COVER SHEET

KENYON RESIDENCE

1010 TARI DR.
PPRBD

A1.3 PLOT PLAN

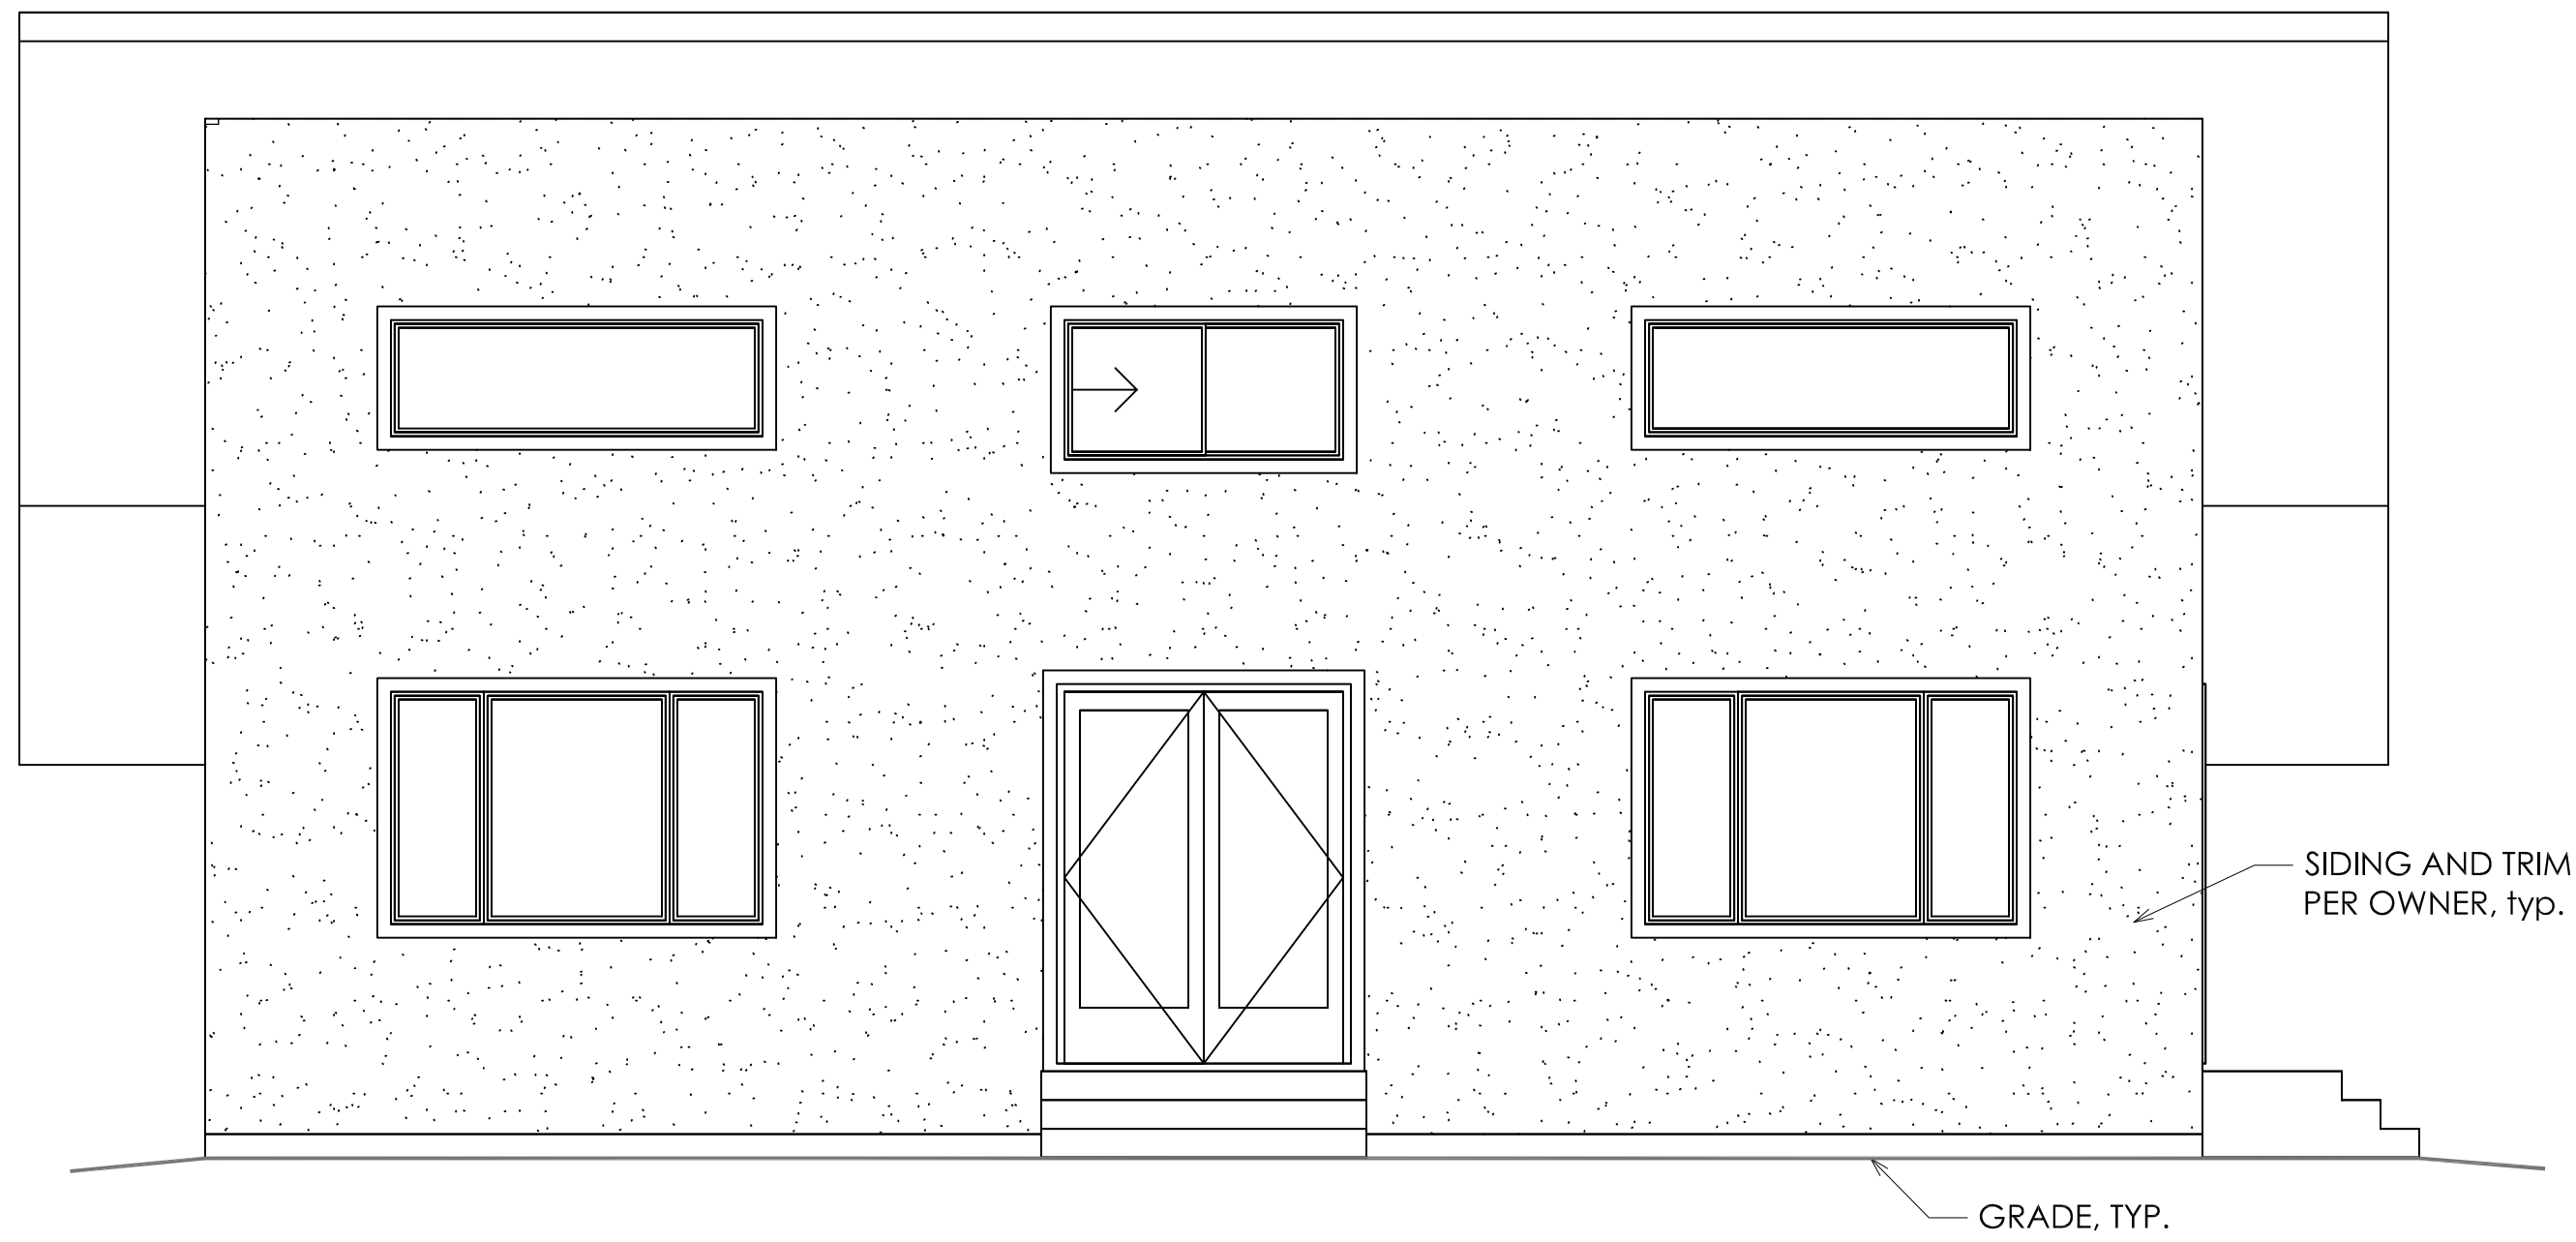
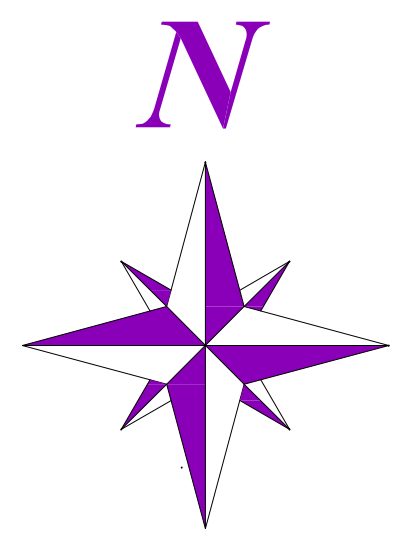
Indicate any proposed or existing easements that exist on the property

Please indicate the footprint of proposed future development to justify the need for relief on the rear setback.

The Land Development Code defines "habitable space" as follows:
The area located inside a dwelling consisting of bathrooms, bedrooms, living rooms, dining rooms, kitchens, dens, loft, or similar space.
